RE: Railway (Metrolink-Estuary to Charlemount via Dublin Airport) Order 2022

21st Nov. 2022

Technical Note Re: MetroLink/HSE 30/31Pearse St.

TARA STATION - LONGITUDINAL SECTION
1 : 200

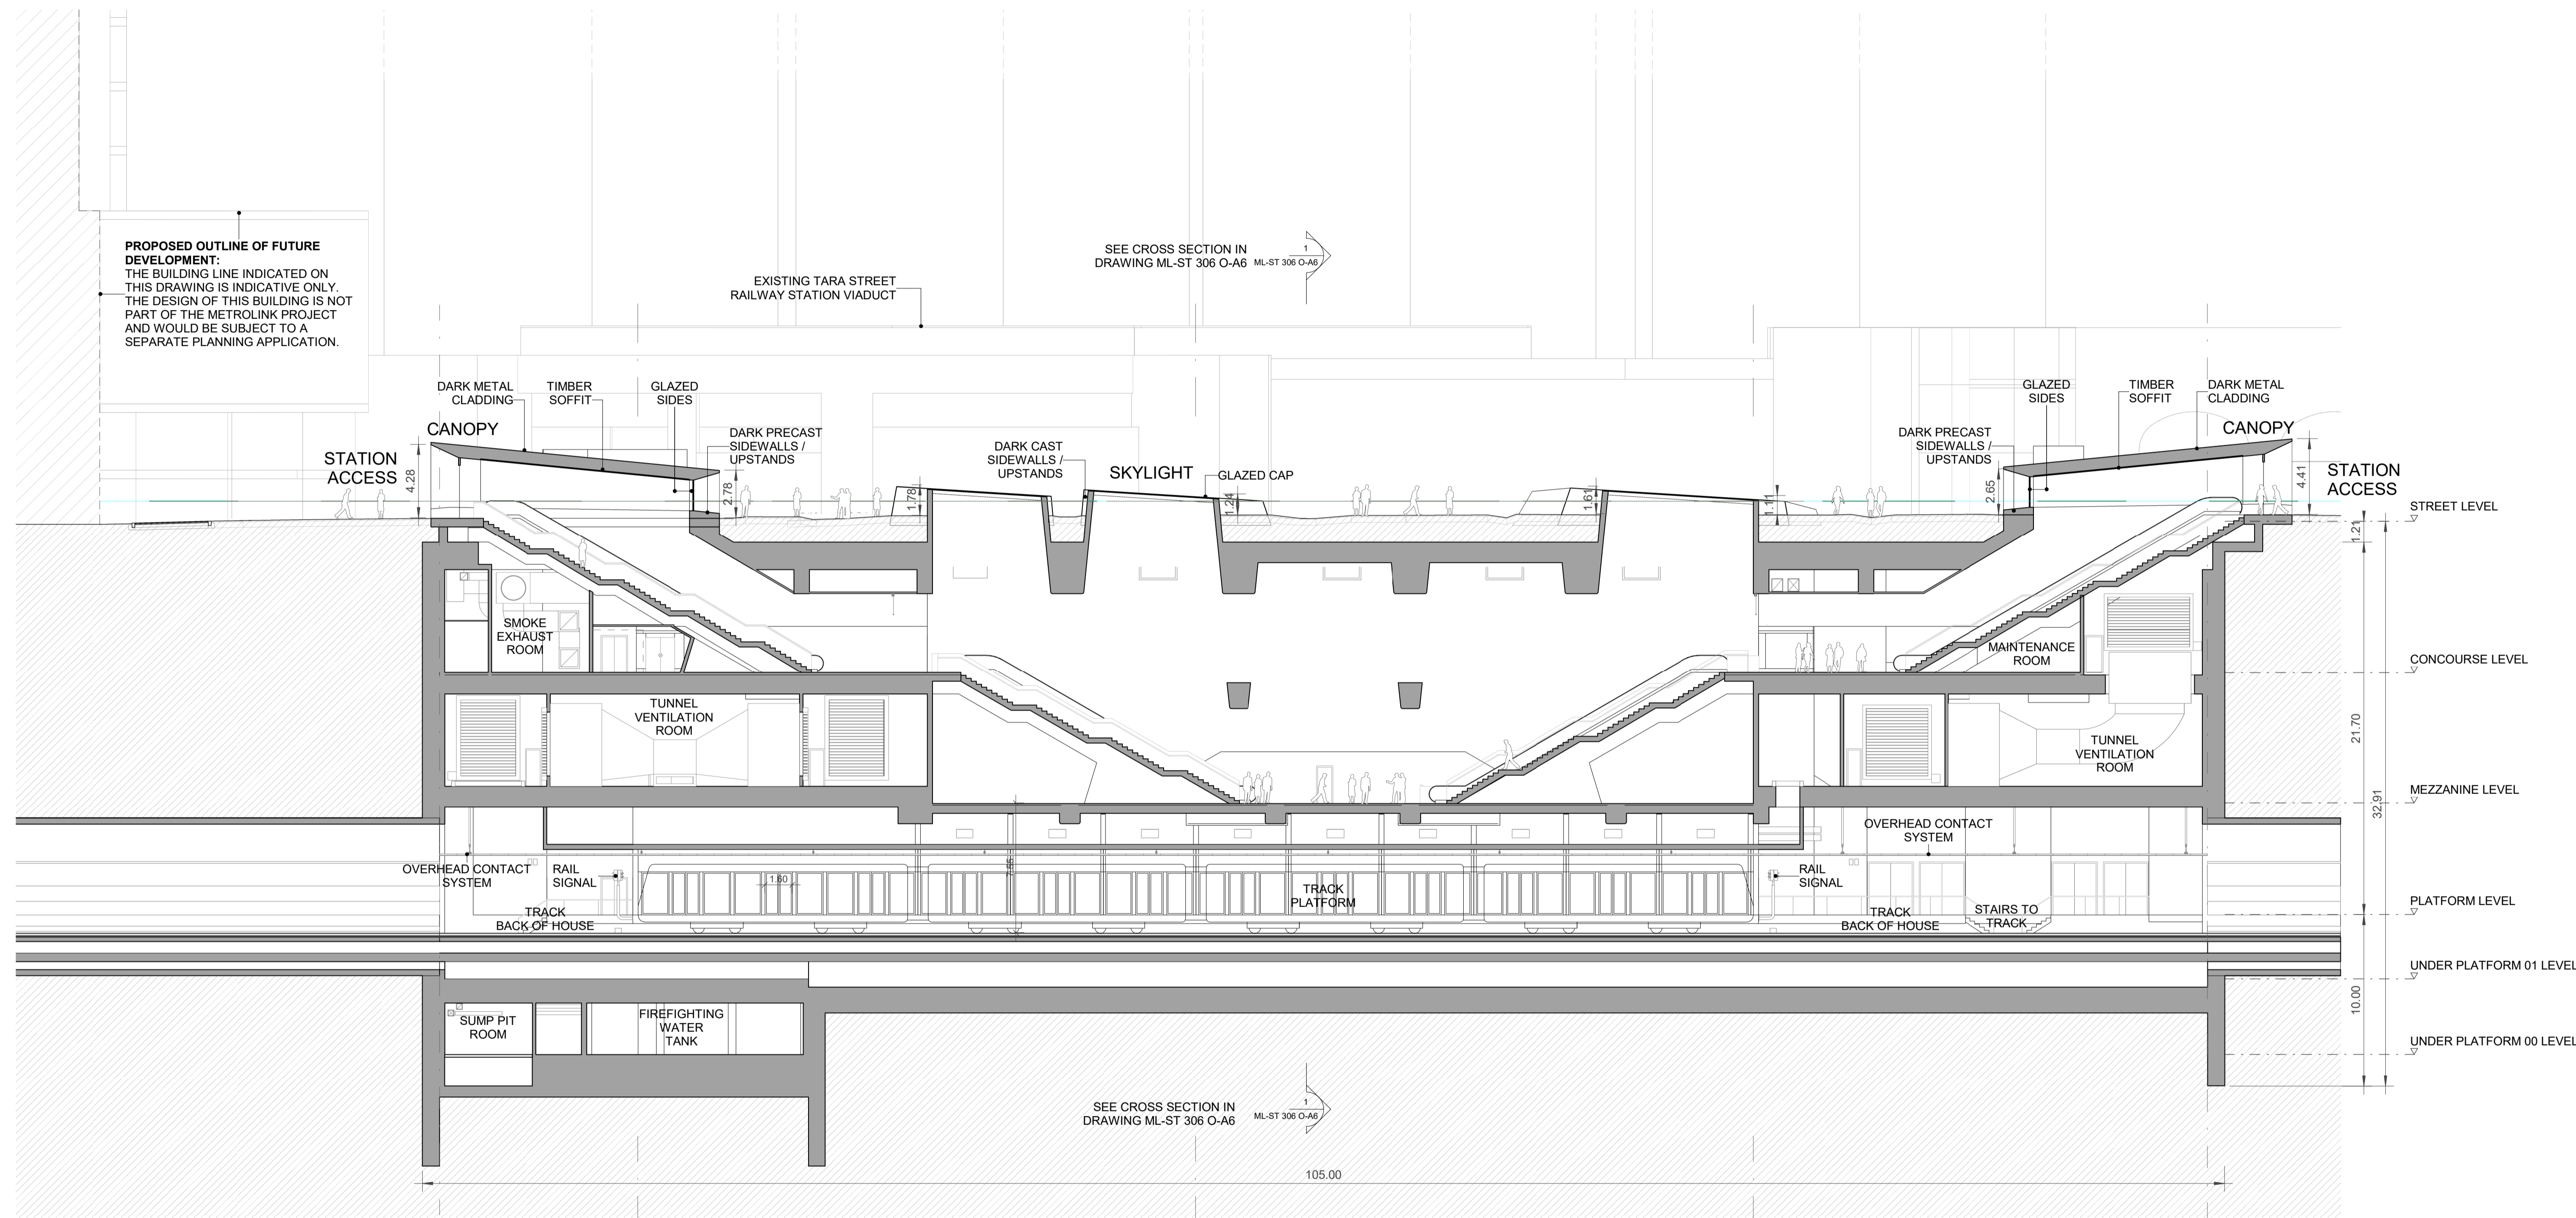
Section 4.7 "Settlement Effects Due to De-Watering" (Appendix A5.17) focuses primarily on Station Box construction and indicates that *"No external dewatering (outside of the site boundaries) will be permitted during the construction of the station boxes, that increases the impact due to settlement on others, beyond the natural ground water fluctuations. Any*

settlement due to the short-term lowering of the water table outside the station box will therefore be constrained to within the site boundaries." This needs to be clarified in the context of Tara Station construction which is in close proximity to 30/31 Pearse St.

Similarly, the rear of 30/31 Pearse St is not too far away from parts of the proposed Tara St station for which as described in section 14.4.1.10, "Blasting" may be used for excavation at underground stations. Table 14.14 "Construction Activities Considered" notes "*Effects on highly sensitive laboratory equipment could occur at up to 1000m if not mitigated.*"

The Applicant should assess the effect of Construction activities (including TBM passage & "Blasting") on the NDTC building and its occupancies for Vibration & Noise.
